**Consultation Response from KC,
Trees**

2026/91628 land off, Boshaw View, Hade Edge, Holmfirth, HD9 2TZ

Erection of 17 dwellings (Use Class C3) together with associated development including access, landscaping, ancillary infrastructure, and parking

Date Responded: 30/06/2026

Site Layout Plan

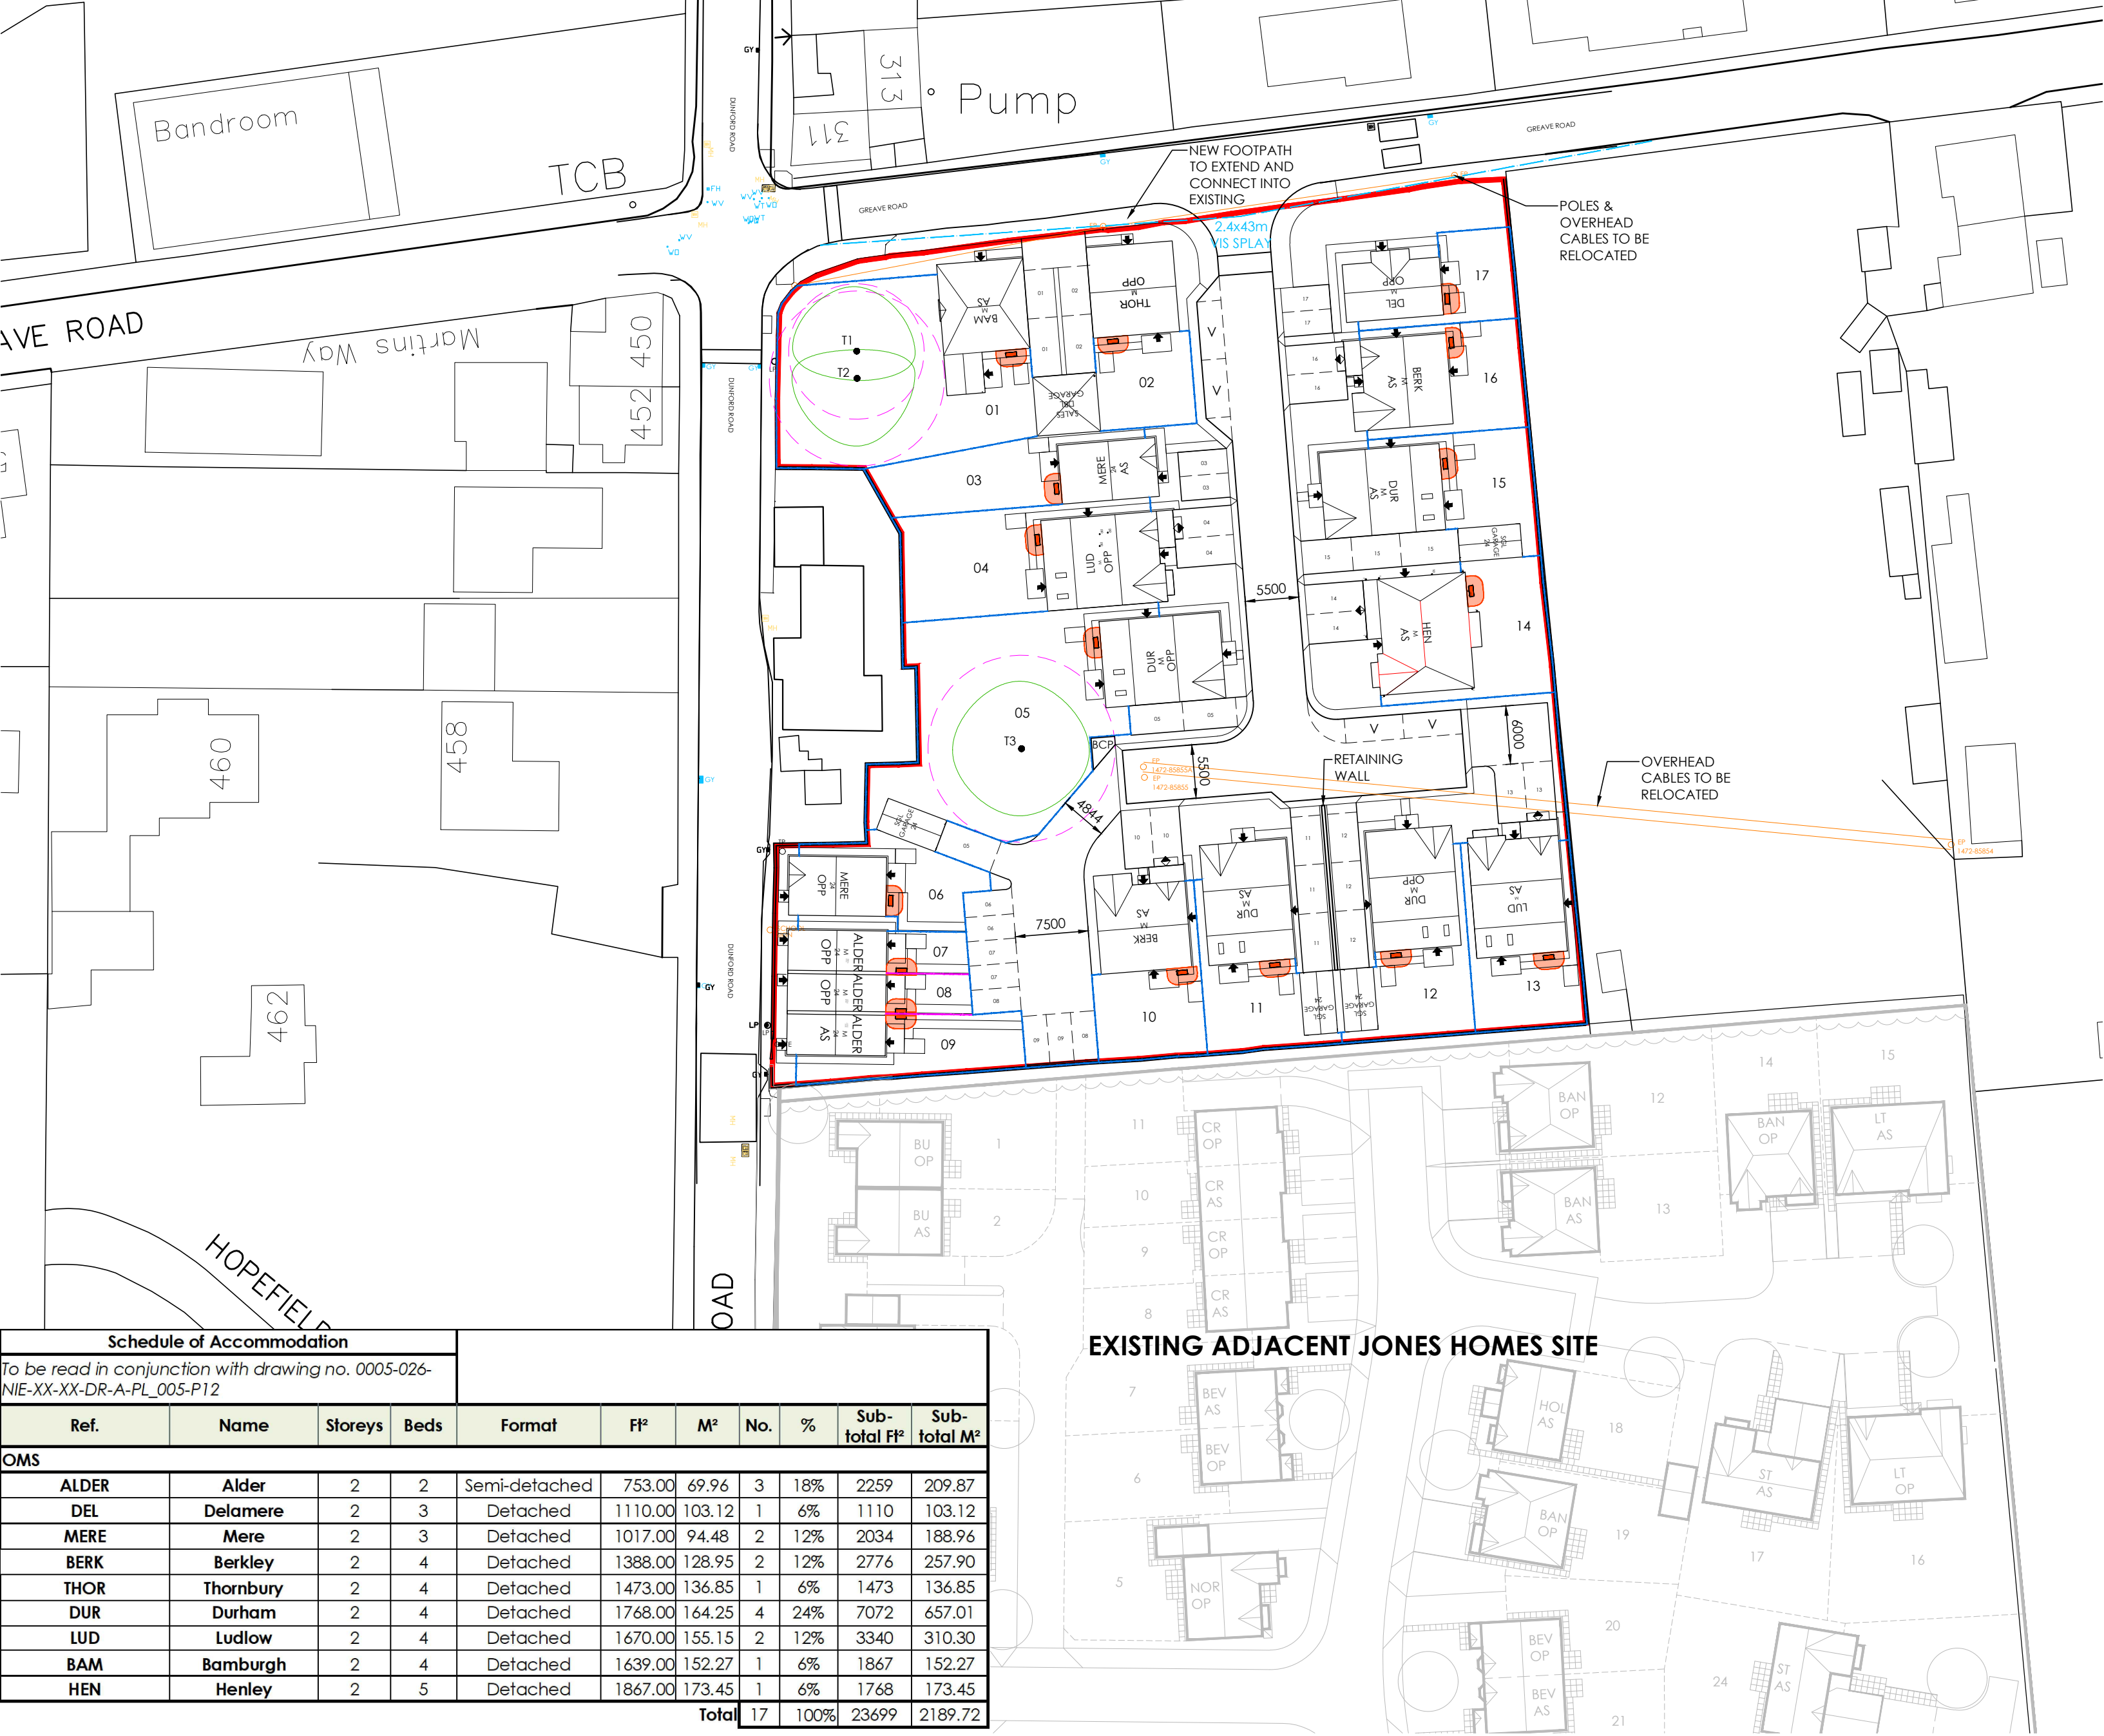
KC trees are of the opinion that there may be some indirect impact on the trees in the form of increased pressure to have the trees removed due to shade and the dropping of detritus. T1 and T2 almost cover the entirety of plot 1's garden. This means there will only be a very small area where there is direct sunlight. Both trees canopy will also be very close to the adjacent roof and may require pruning in the not to distant future. There may be an alternative design option turning Plot1 and Plot 2 90° making T1 and T2 at the end of the gardens and leaving more distance between trees and property.

The same issues apply to T3 in the garden of Plot 5 with the added problem of the tree's location being south of the rest of the usable garden. This means this garden will almost receive no direct sunlight also resulting in pressure to have work performed on the tree if not pressure to remove it entirely.

There is a holding objection until the alternative design options have been explored. These trees could make a great addition to the development if they are given due space.
